The Planning Inspectorate Yr Arolygiaeth Gynllunio

Meeting note

File reference	EN010020
Status	Final
Author	James Bunten
Date	29 May 2014
Meeting with	Mynydd y Gwynt Ltd (the applicant)
Venue	The Planning Inspectorate offices, Bristol
Attendees	<u>For The Applicant</u> David Harries – Aaron and Partners (A&P) Keith McKinney – A&P William Little – Environmental Planning Solutions <u>The Planning Inspectorate</u> Simone Wilding – Head of Service Emre Williams – Case Leader Andrew Luke – Infrastructure Planning Lead Justin John – Legal Advisor Laura Allen – Senior EIA and Land Rights Advisor Karen Jones – EIA and Land Rights Advisor James Bunten – Case Officer
Meeting objectives	Meeting with the applicant to provide feedback following the decision to withdraw the Mynydd y Gwynt Wind Farm application
Circulation	All above

**Mynydd y Gwynt
Proposed Wind Farm
Water Catchments,
Drainage Direction and
Private Water Supplies**

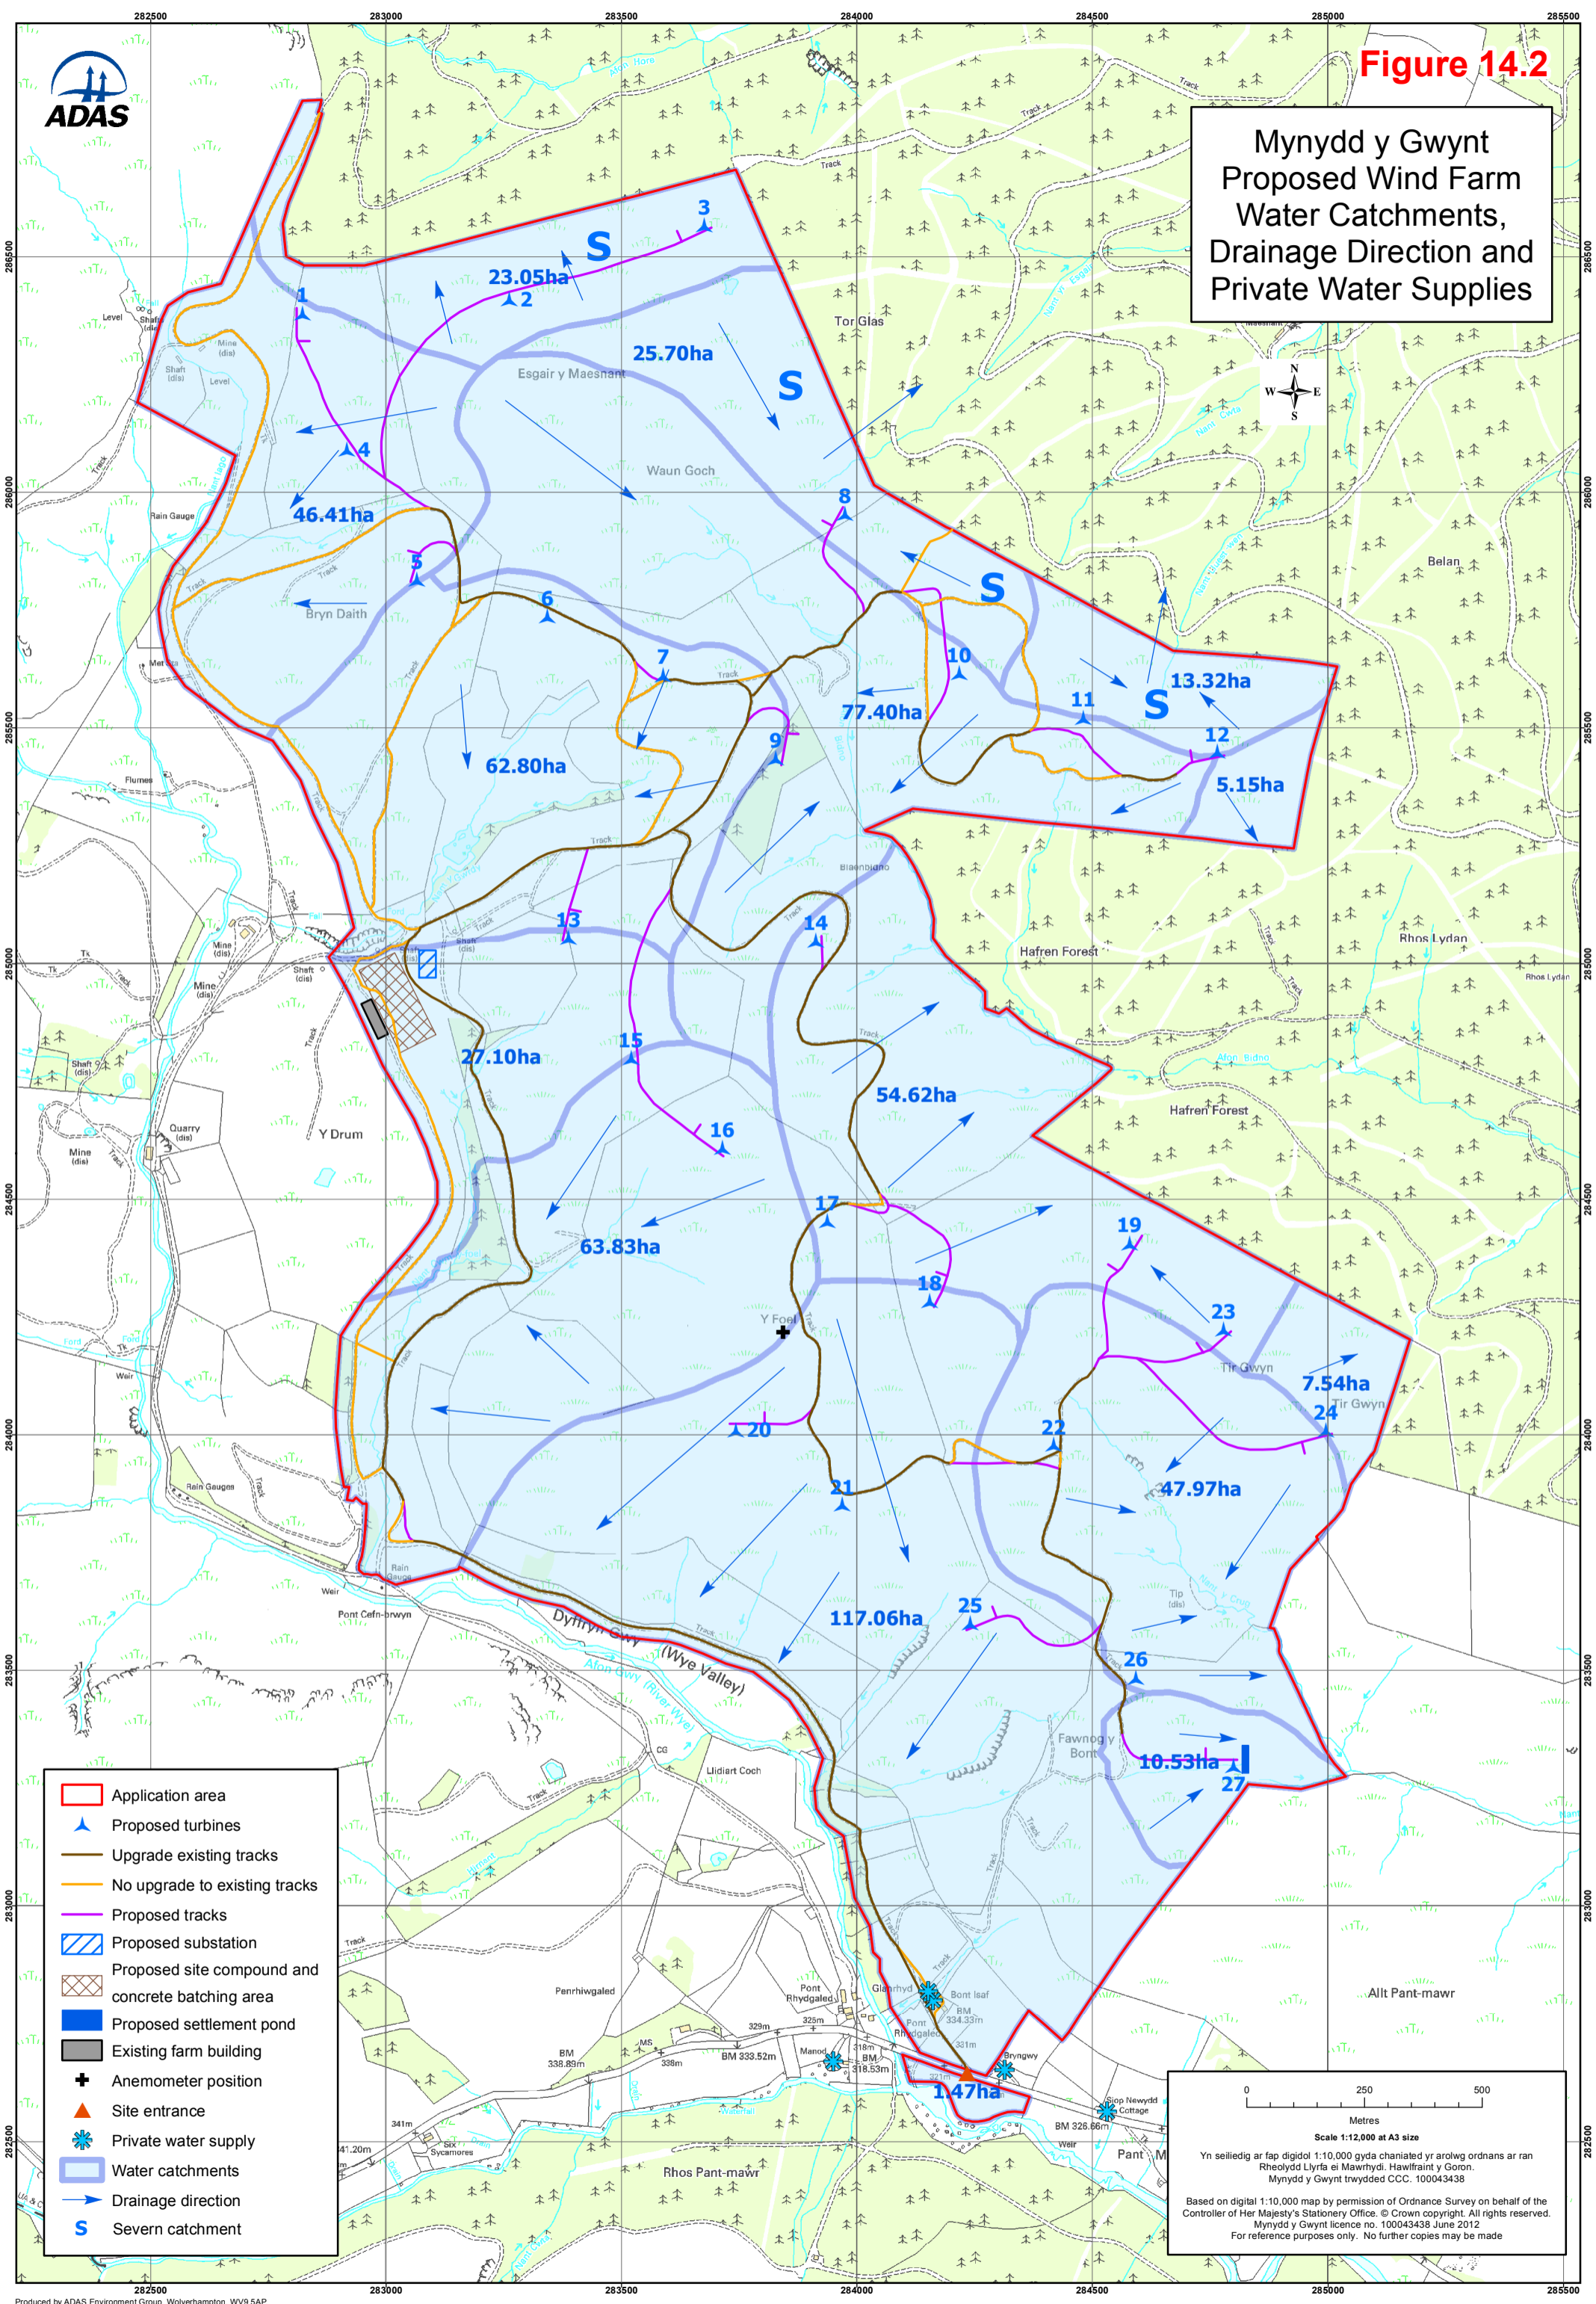
It was also noted that it would be helpful to include a plan showing rivers, catchment areas and European sites in order to demonstrate the presence or absence of any environmental pathways.
